CITY OF ALBUQUERQUE

**RE: Anasazi Downtown
Request For Permanent C.O.
Engineer's Stamp Date: 10-26-2006 (K14D095)
Certification Stamp Date: 05-15-14**

Re: Anasazi Downtown, Engineer's Stamp dated 10-13-06 (K14/D95)
Lots 10, 11, and 12, Block 19 of the NM Town Co. Original Townsite

sheet-  
C101

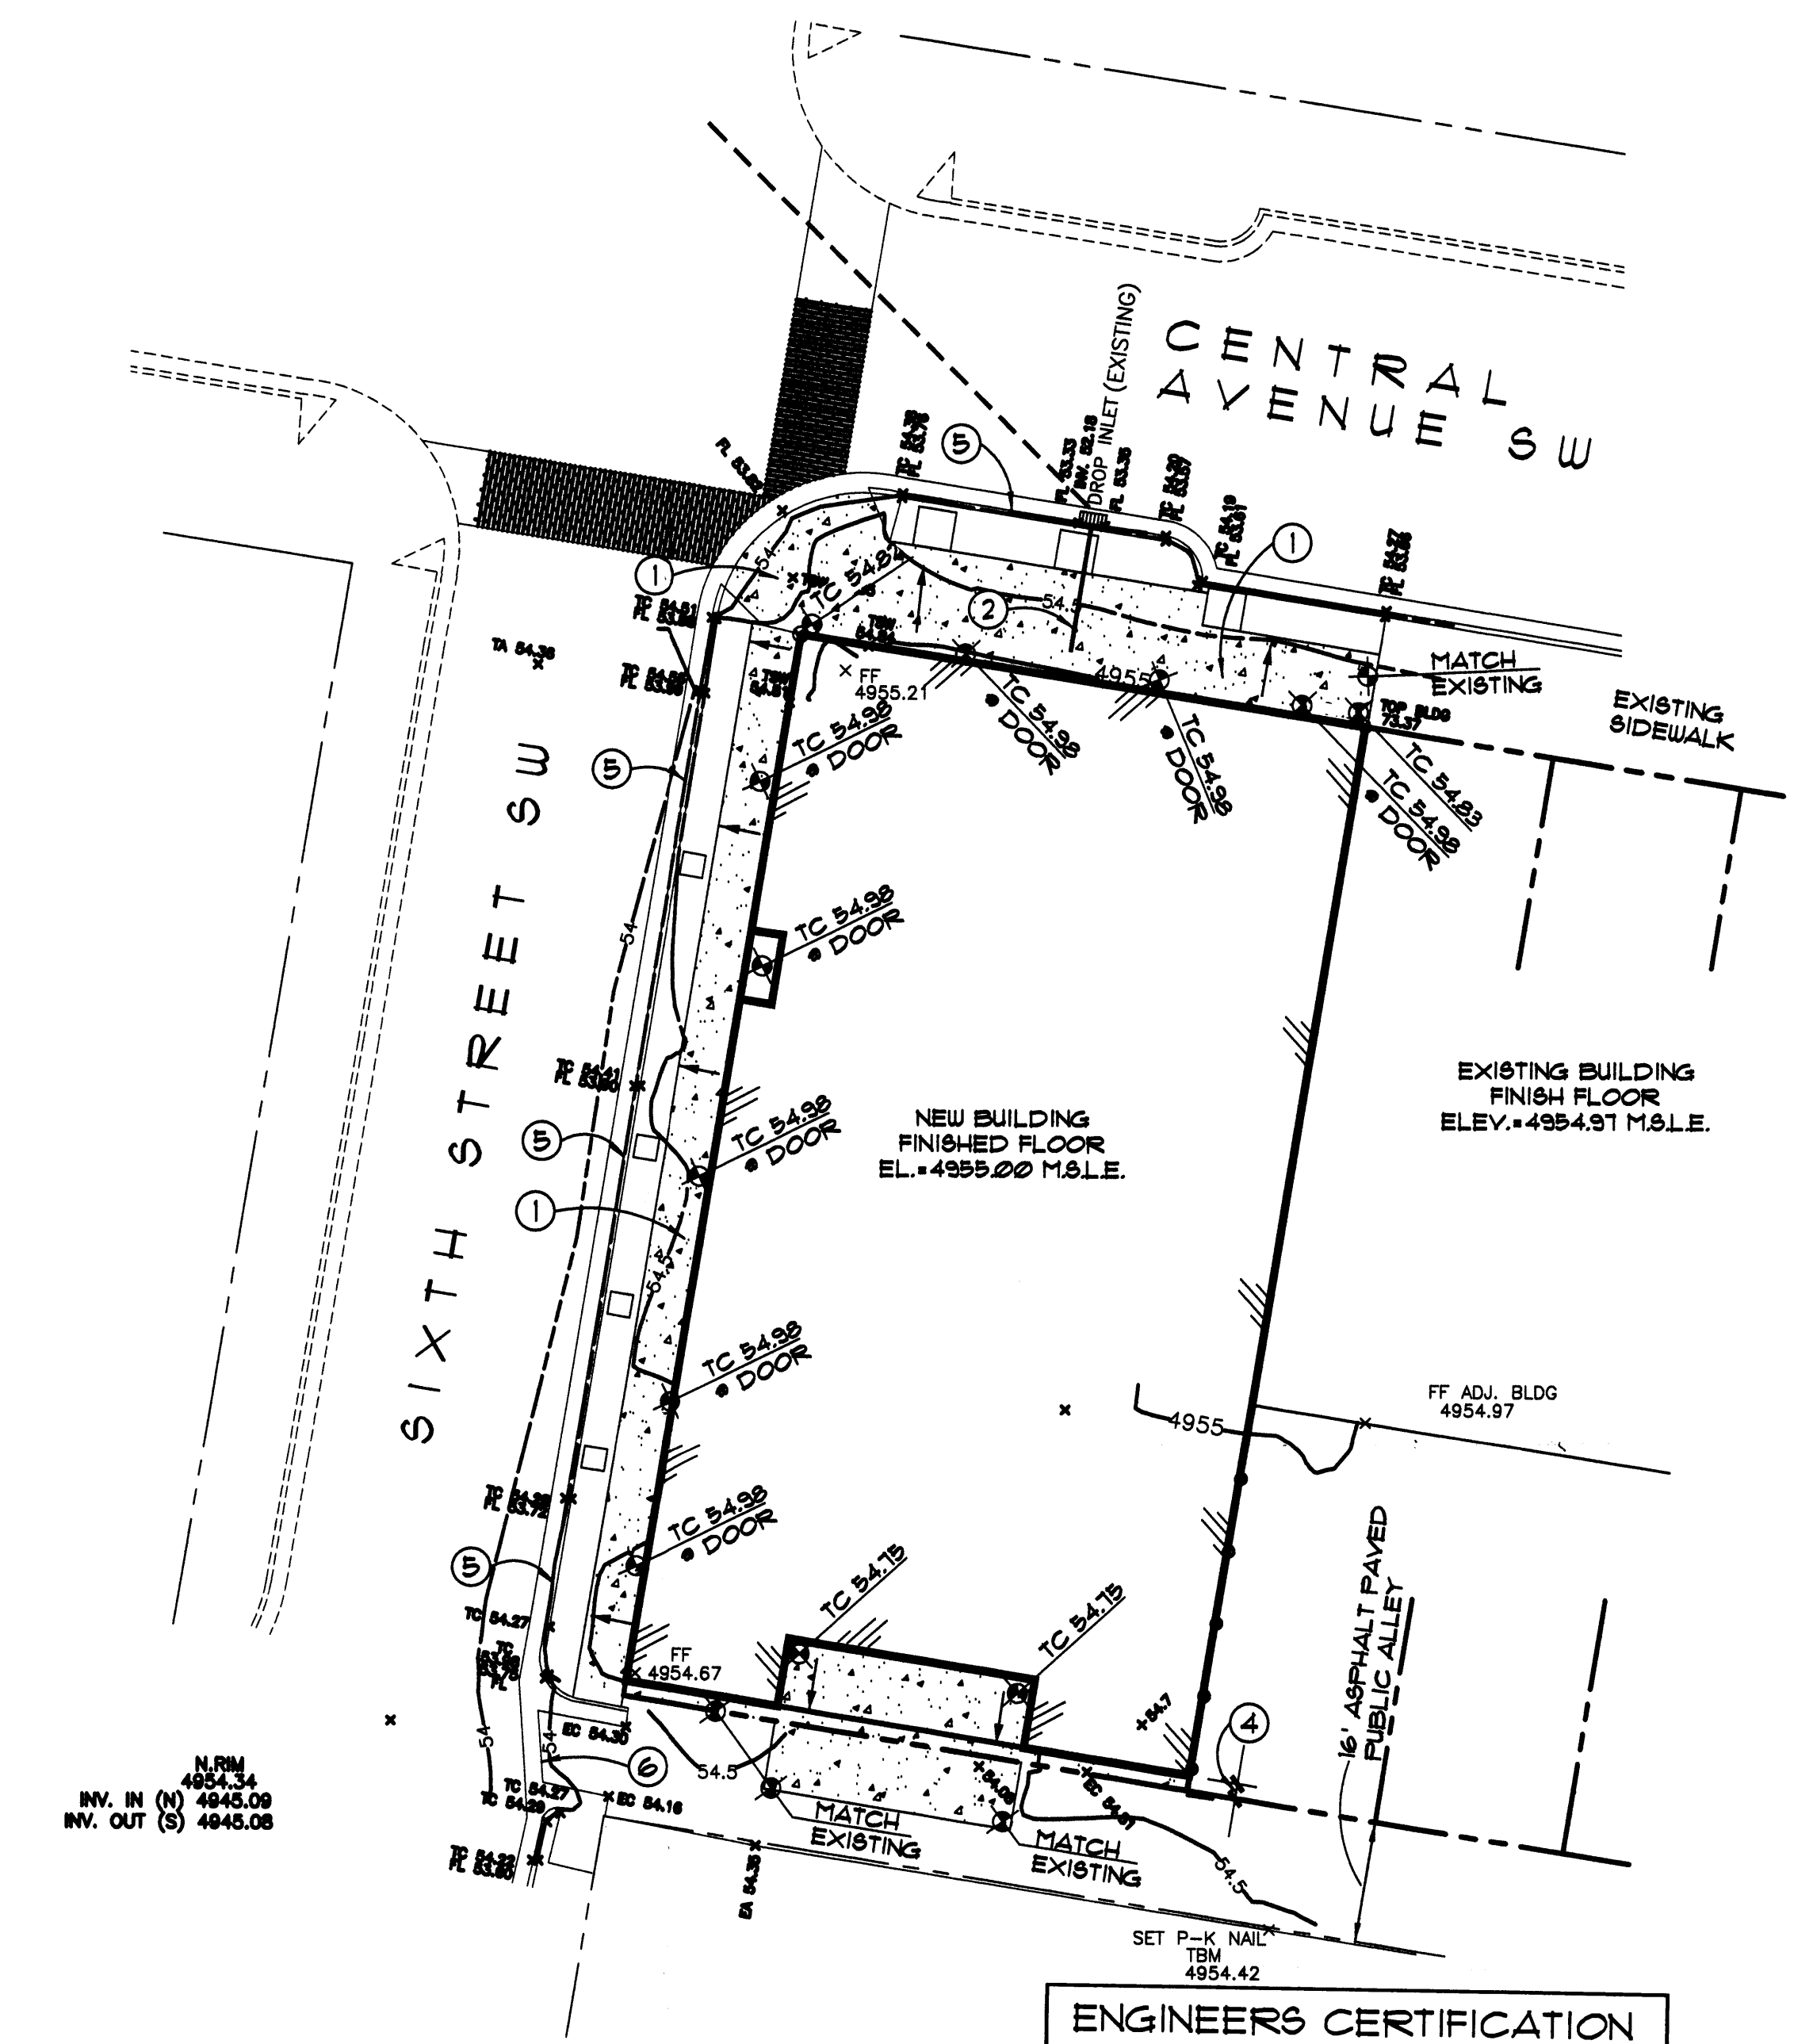
- The connection to the existing storm drain inlet in Central will require an SO-19 permit. Please include the appropriate construction notes associated with that permit. A copy is included as an attachment to this document for your reference.
- Please graphically show the roof flow directions and provide a drainage narrative discussing the flow conditions. It appears that the intention is to drain the rooftop to Central. However, the flow arrows you show along the north and west sidewalks suggest otherwise. Are these intended to indicate sidewalk slopes?
